Planning Services Sign Permit Review Form

Date of Submittal	Application Number	Applicant	Landowner
05-20-19	SIGN 1905-0002	Sign + Awning Systems	Elmwood Holdings LLC
Contact Person	Contact Number	Sign Location	PIN Number
Rachel Taylor	910-892-5900	1554 NC 24-87	9584-88-6096

Proposed Sign			
Type	Dimensions	Location / Setbacks	Illumination
<input checked="" type="checkbox"/> Wall <input type="checkbox"/> Ground <input type="checkbox"/> Monument <input type="checkbox"/> Directory <input type="checkbox"/> Outdoor Advertising	Length Width 14.08' Height 2.83' Total Sq. Ft. 39.8464 sq. ft.	N/A	<input type="checkbox"/> None <input type="checkbox"/> External <input checked="" type="checkbox"/> Internal <input type="checkbox"/> Electronic Message
Total Length of Wall	40 ft	Total Size of Project / Parcel	<input type="checkbox"/> Less Than 1 Acre <input checked="" type="checkbox"/> Greater Than 1 Acre
Total Sq. Ft. Electronic Message Display	N/A	Pole Style Ground Sign Encasement	Material Width N/A

EL CAZADOR MEXICAN RESTAURANT
 1554 NC-24 CAMERON, NC
FLOOR PLAN

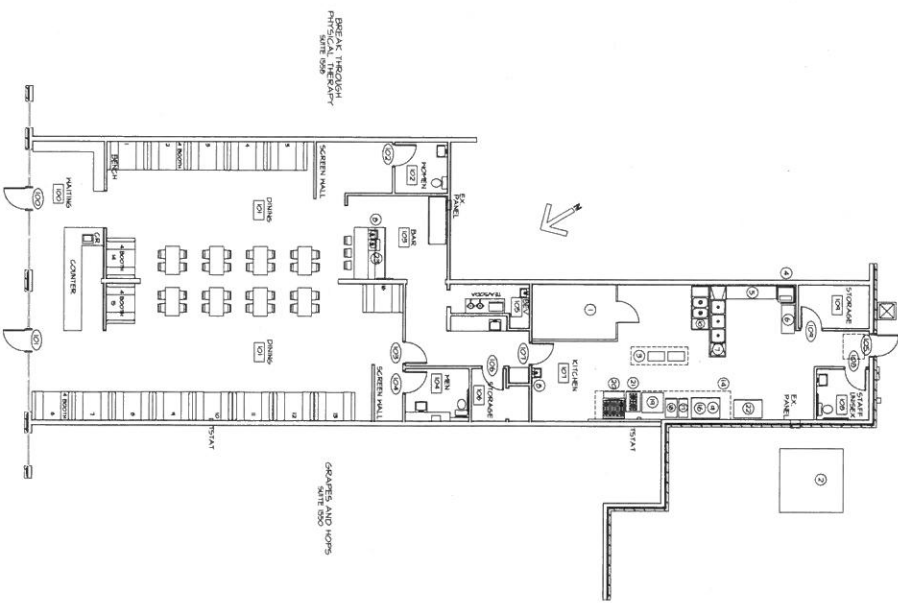
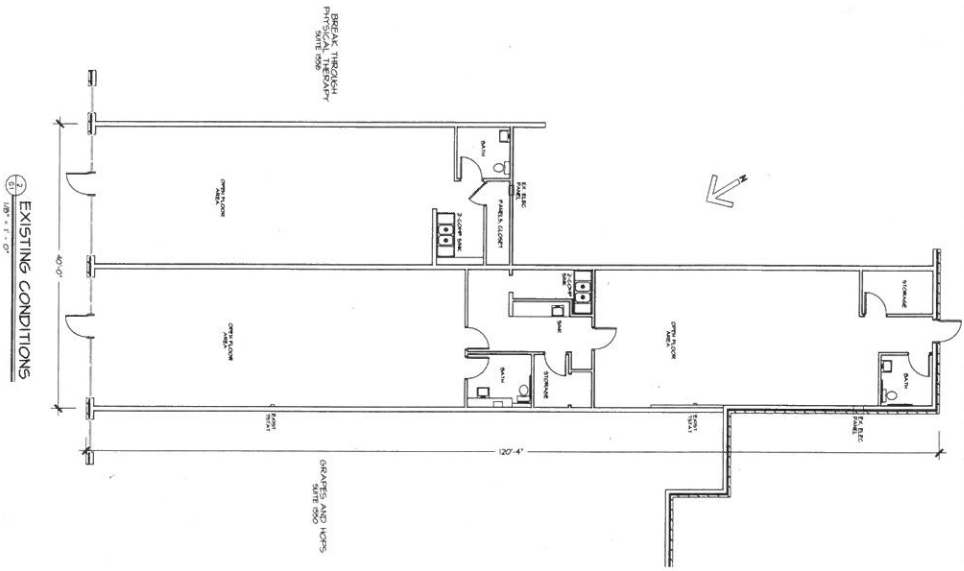
Comments	
Per BCOM 1902-0005 plans the lease space is 40 ft wide See plan attached to file

**EL CAZADOR RESTAURANT**

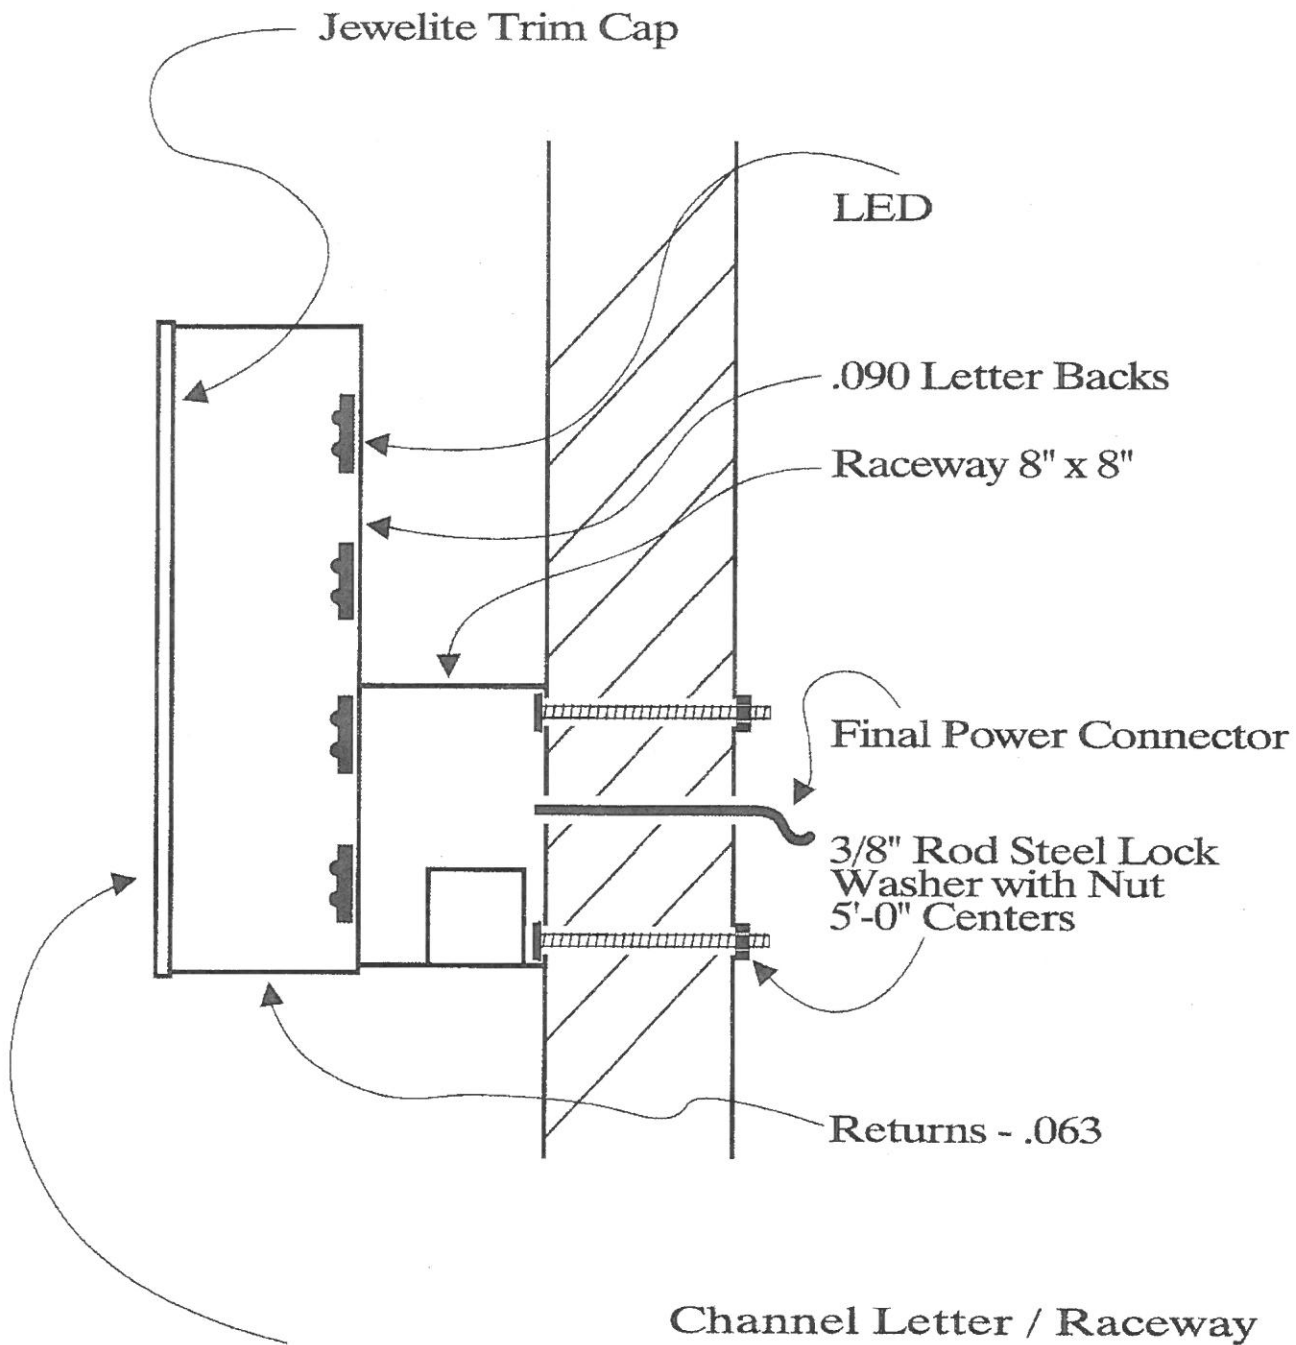
Wall Sign: 169" x 34"

= 14.08' x 2.83'

= 39.8464 sq. ft = ok ✓
